From: Debbie Farrell 
Sent: 29 January 2019 16:31
To: Planning.Responses
Cc: Anita Gardner; Andrew Wood
Subject: **Warning Active Content** FW: Planning Consultation on FG/4/19/DOC

Site Address: Garage Premises Littlehampton Road Ferring BN12 6PB

Description of Works: Approval of details reserved by condition imposed under ref FG/39/18/PL relating to Condition No 7 hard & soft landscaping and Condition No 11 control of car transporters & deliveries.

TO:	Arun District Council FAO: Andrew Wood	
FROM:	Highways, WSCC	
DATE:	29 January 2019	
LOCATION:	Garage Premises, Littlehampton Road, Ferring, Worthing, BN12 6PB	
SUBJECT:	FG/4/19/DOC Approval of details reserved by condition imposed under ref FG/39/18/PL relating to Condition No 7 hard & soft landscaping and Condition No 11 control of car transporters & deliveries.	
DATE OF SITE VISIT:		
RECOMMENDATION:	☐ Advice ☐ Objection ☐ Modification ☐ No Objection ☒ More Information ☐ Refusal	
S106 CONTRIBUTION TOTAL:

Drawing Title
**Proposed Hard & Soft Landscaping
Plan**

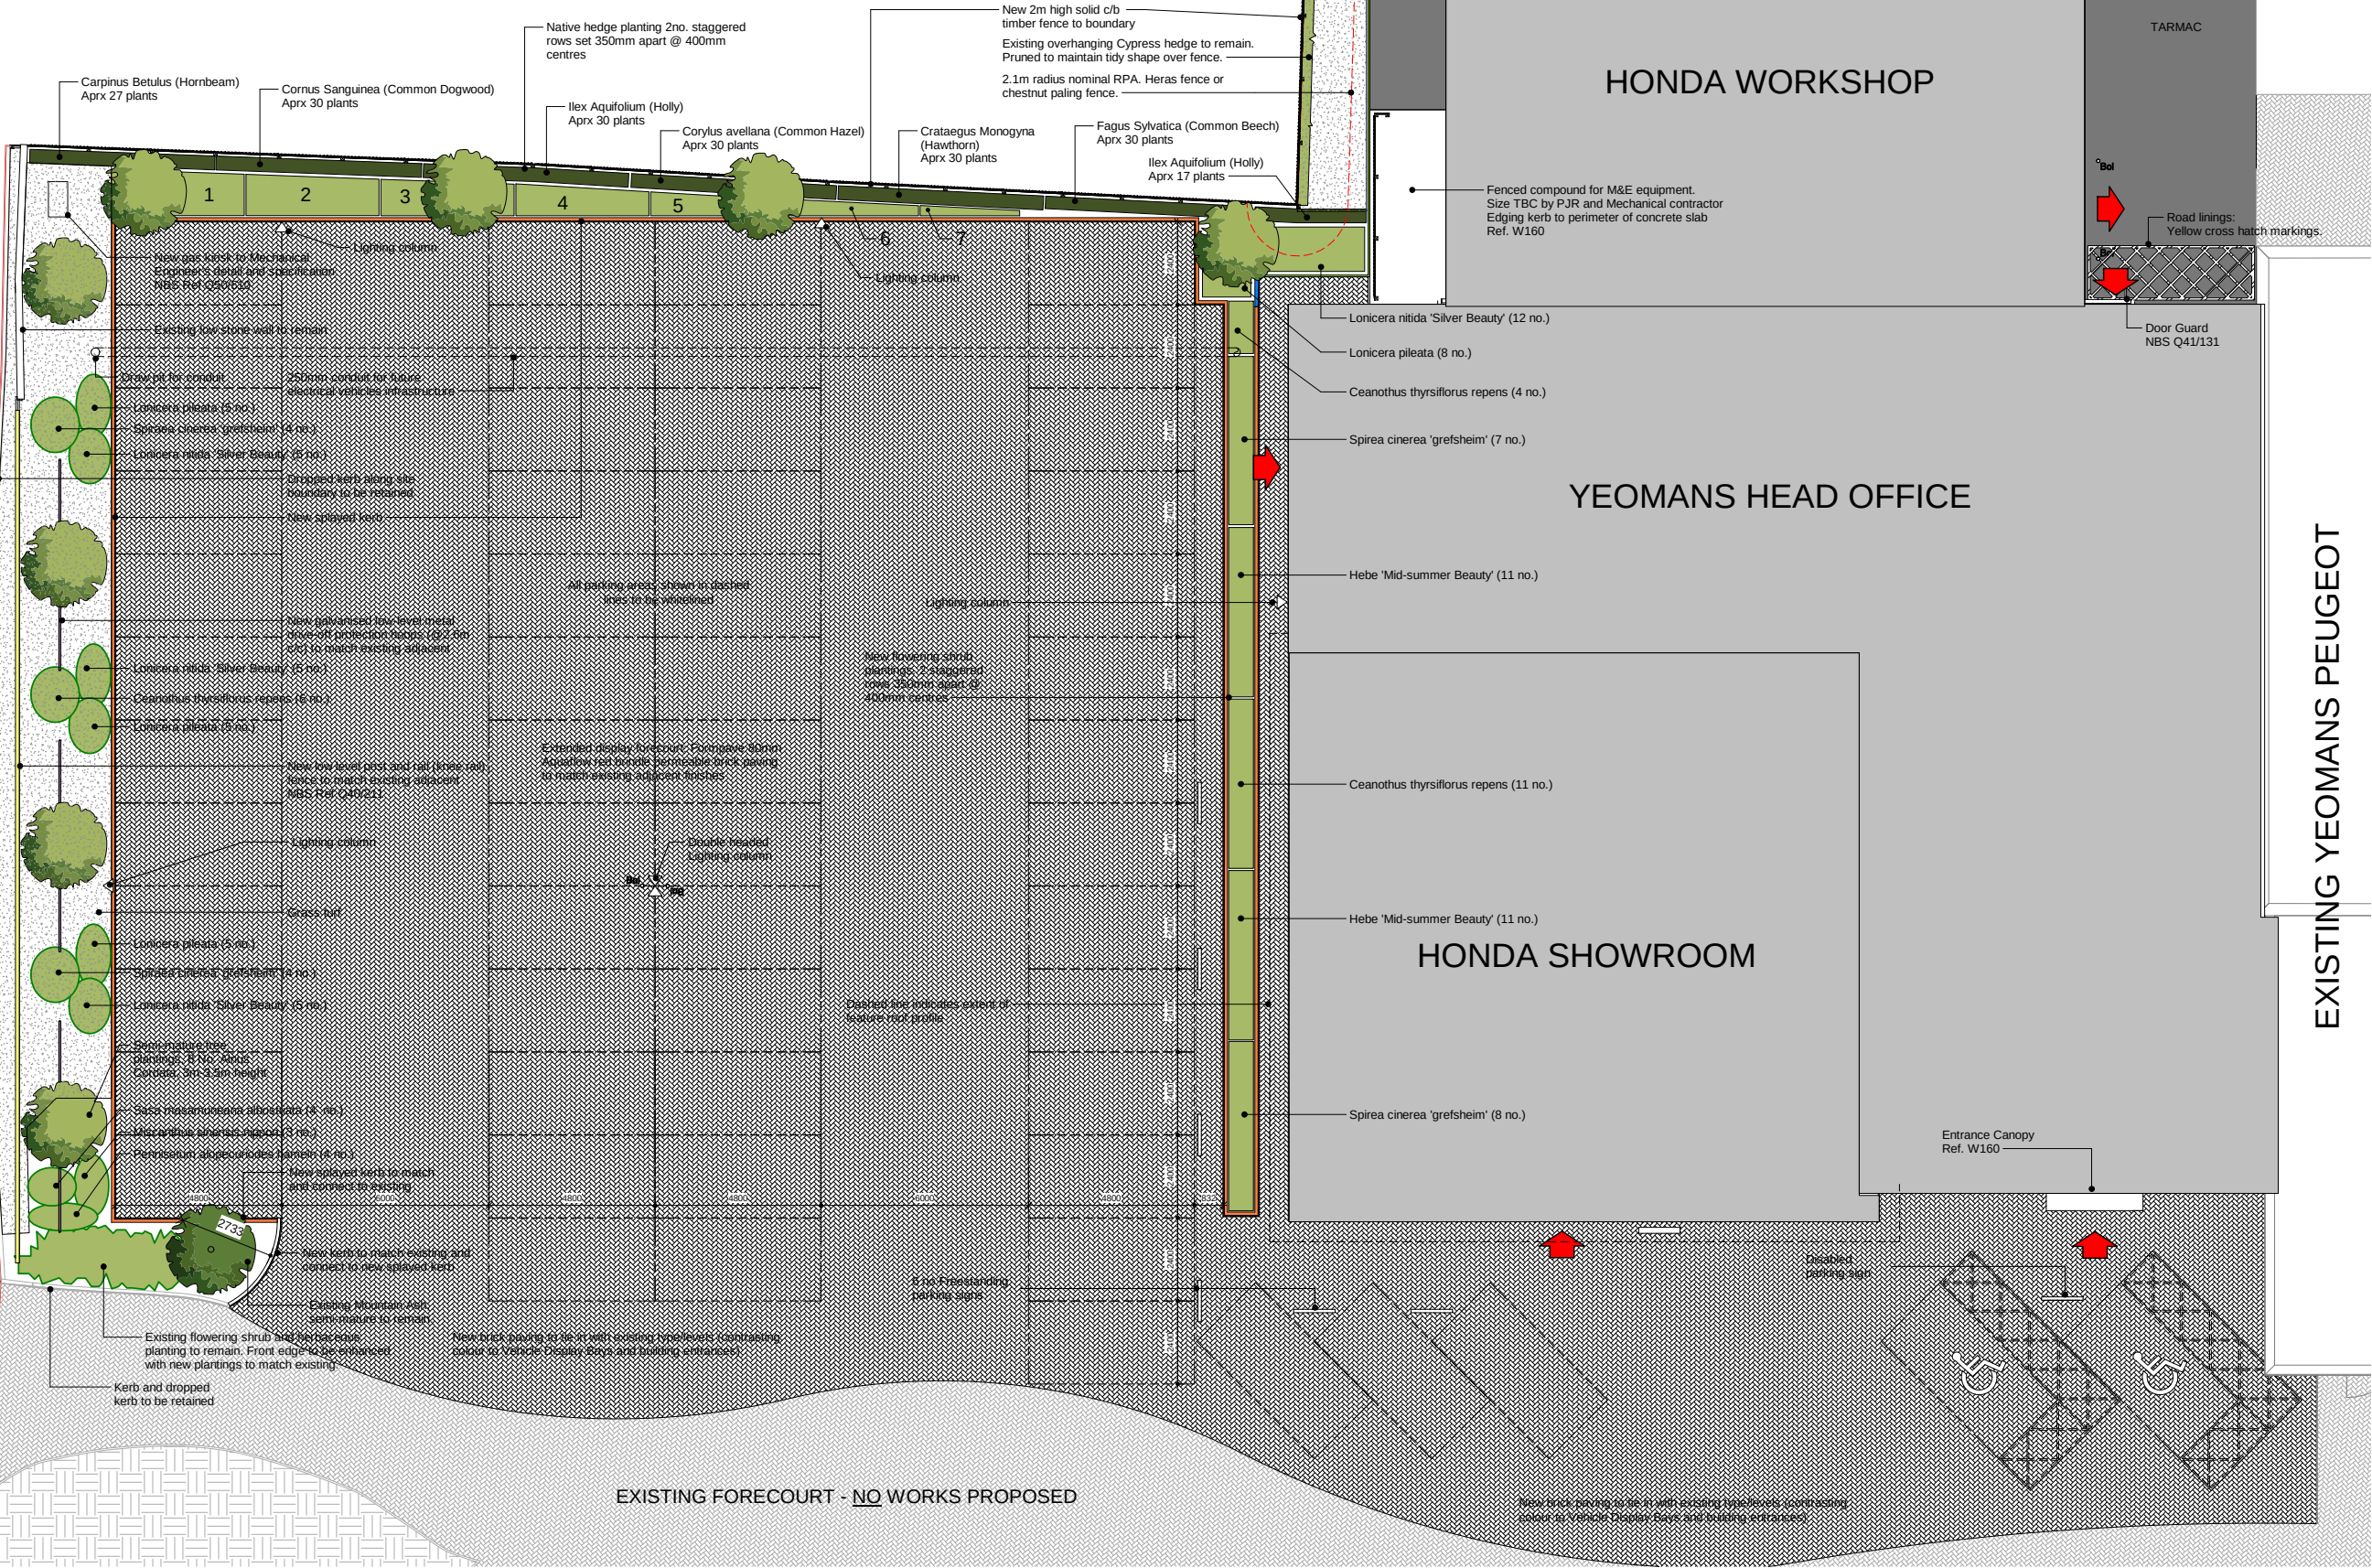
Condition 7 – Hard and soft landscaping. Not generally highways related, however parking spaces are clearly marked on the plan.

020.0347.001

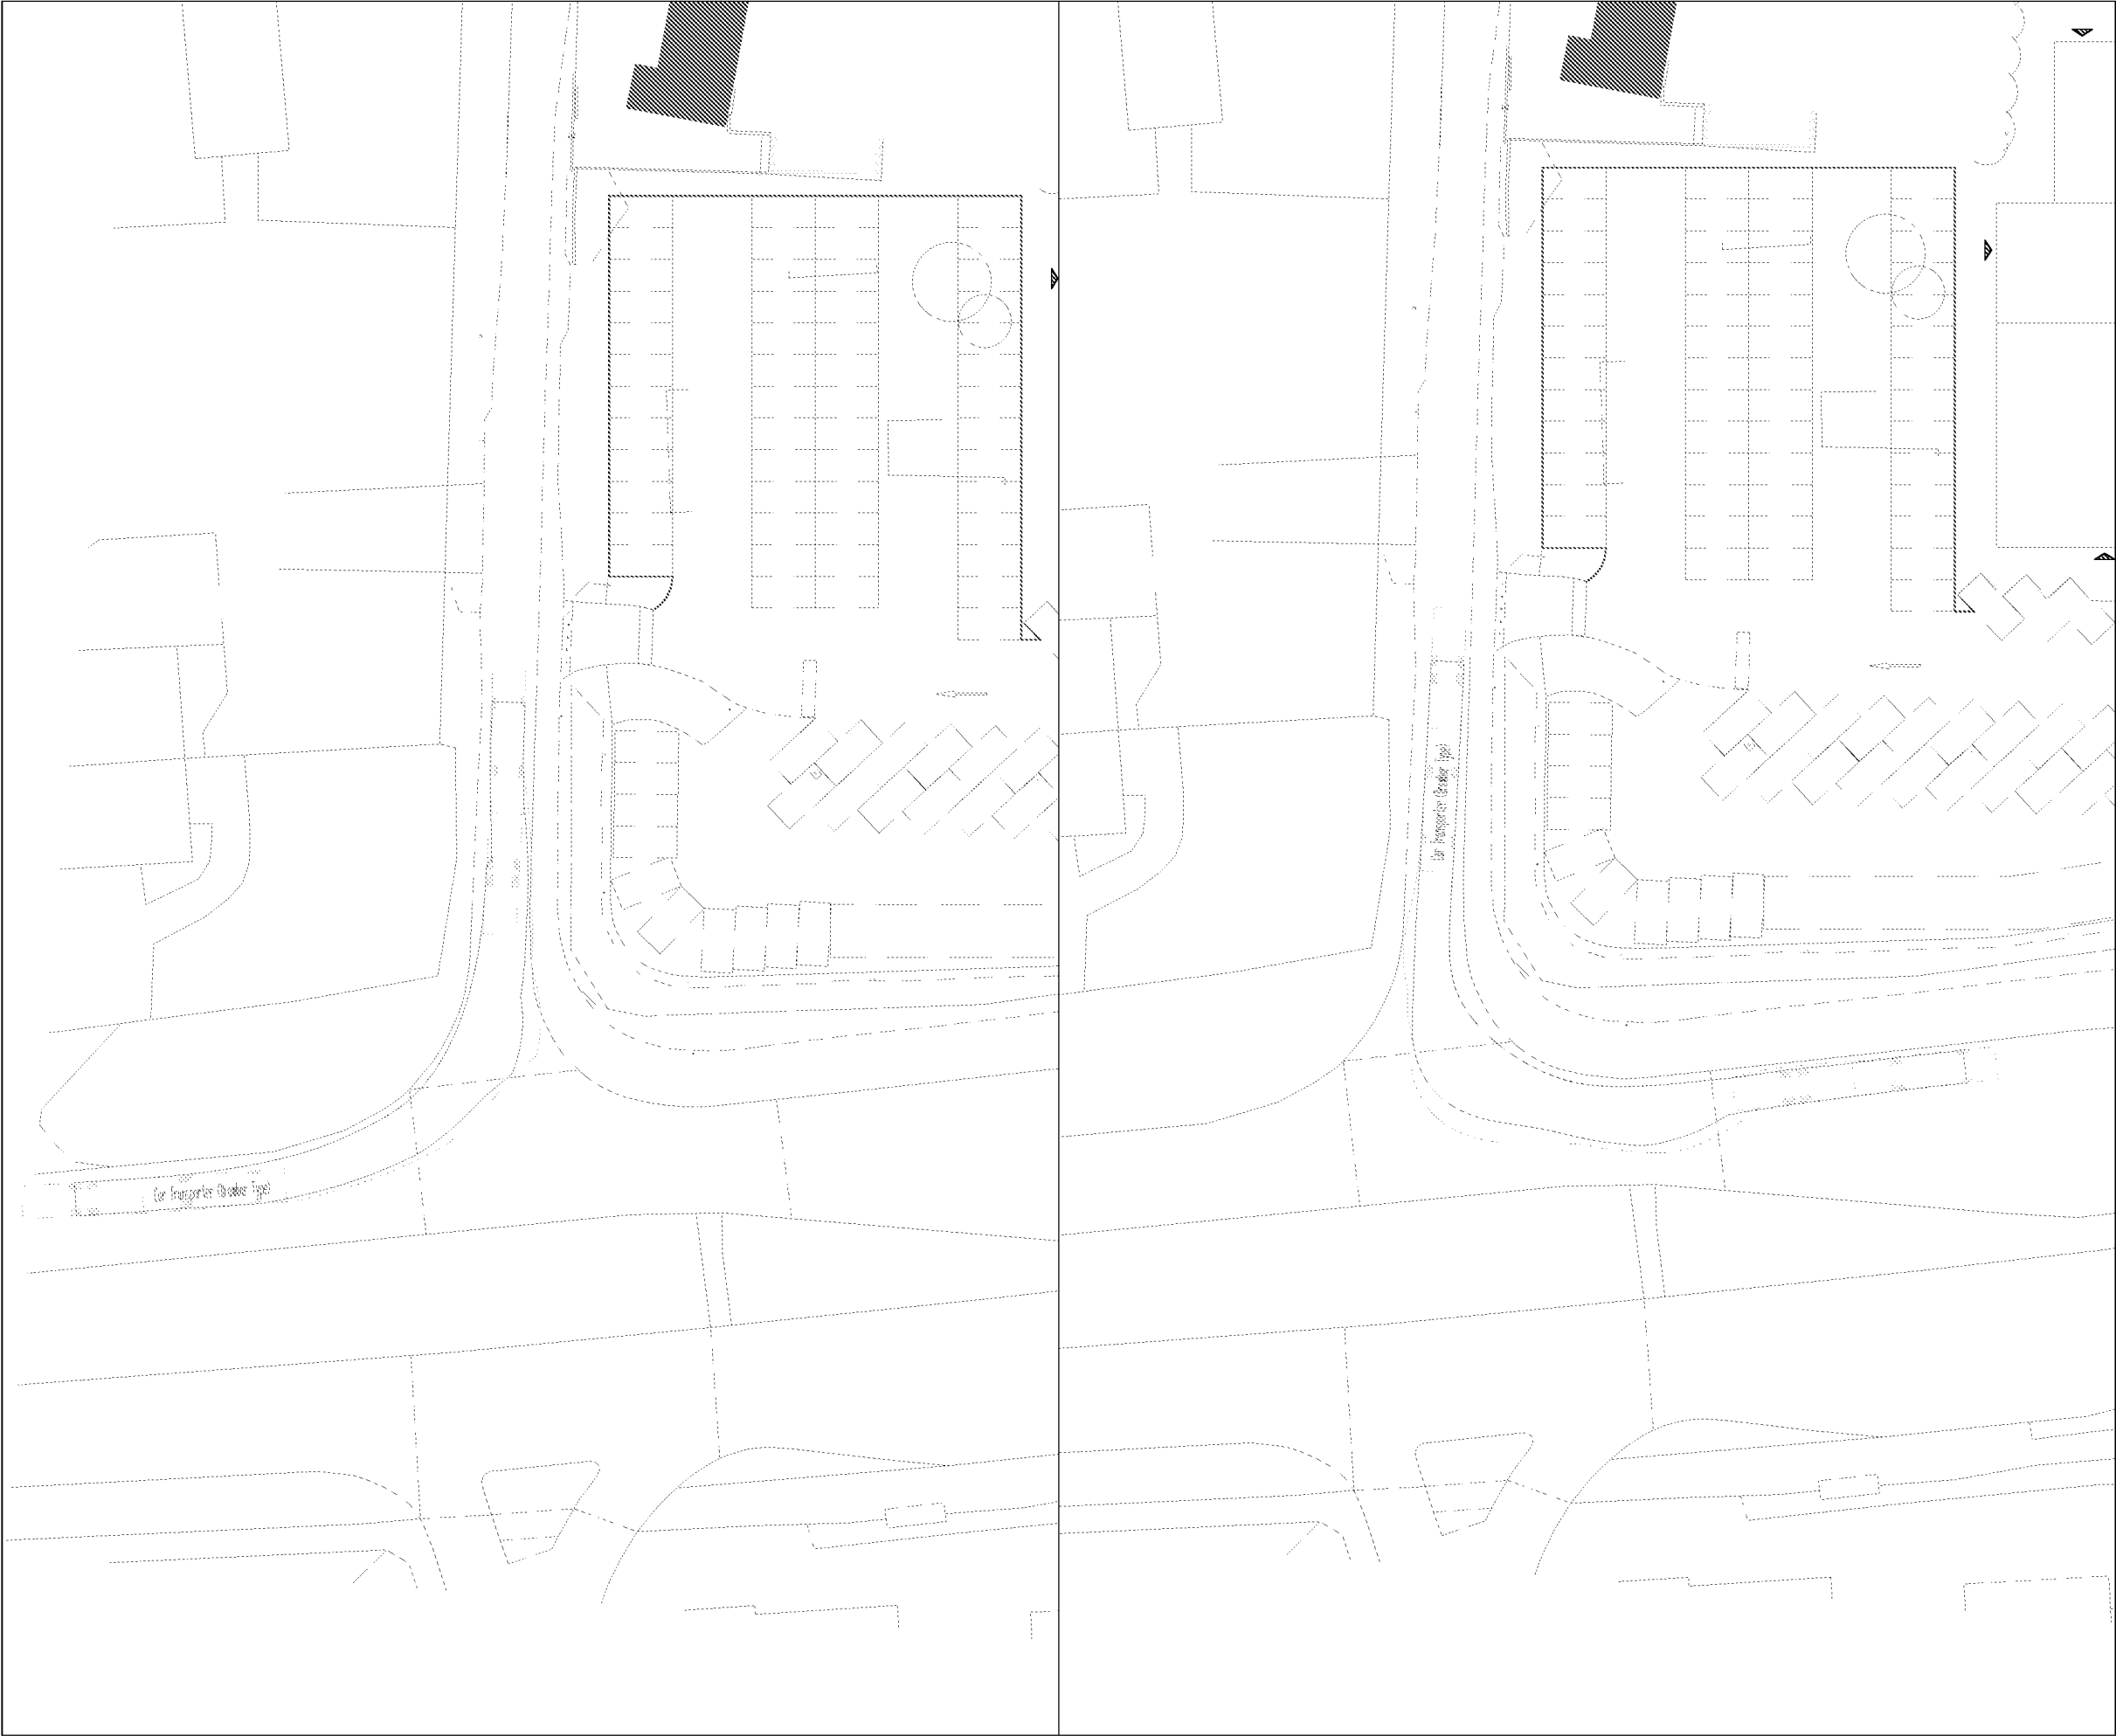
In addition, the indicative widening works to the access in Hangleton Lane shown on Drawing 020.0347.001 forming part of PA A/114/17/PL will need to be undertaken prior to occupation.

APPENDIX D – CRANAGE

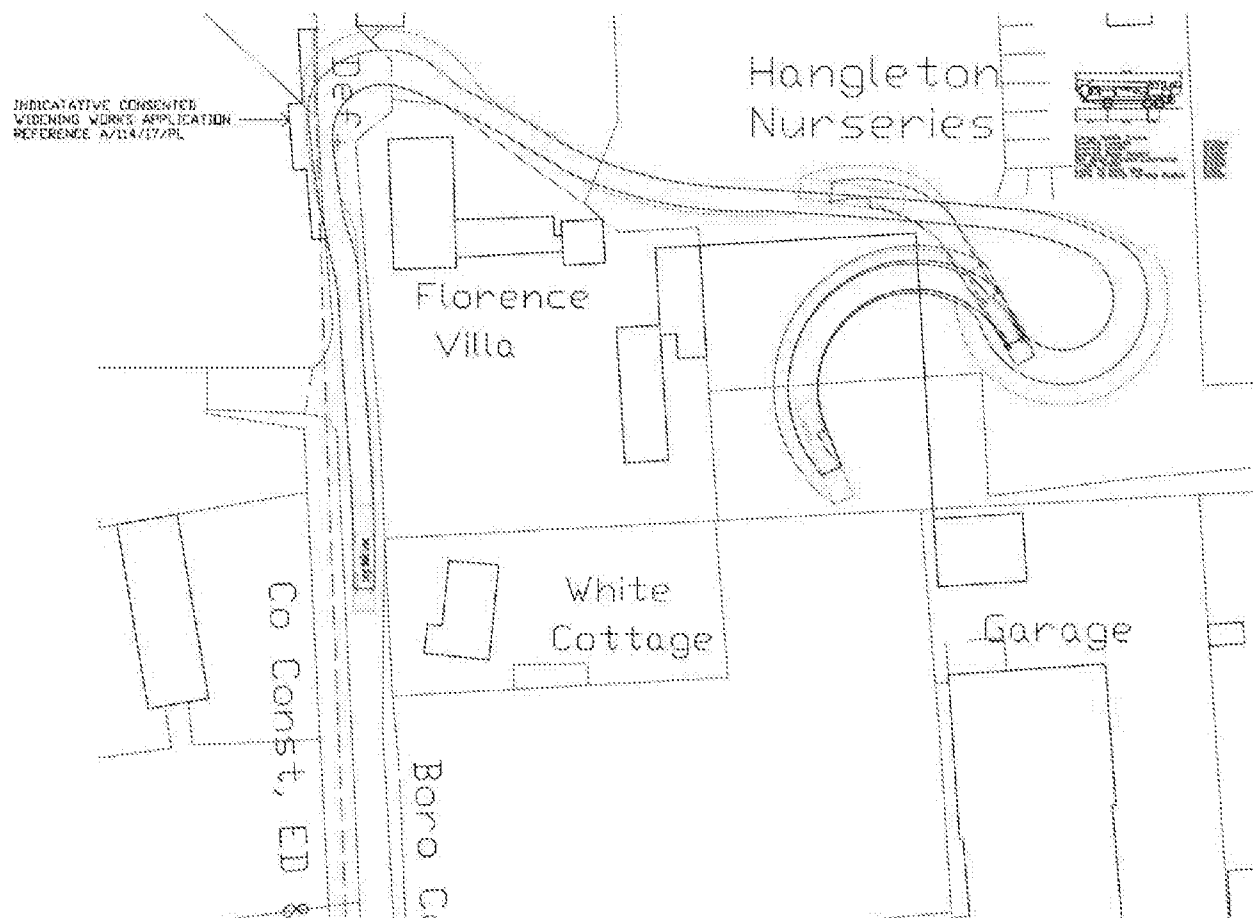
In reference to our previous response dated 14/1/19 to FG/171/18 for the Discharge of Conditions – Construction Management Plan. It may be helpful to request the applicant shows the swept path of the Crane on a drawing which also shows the widening permitted under PA A/114/17.
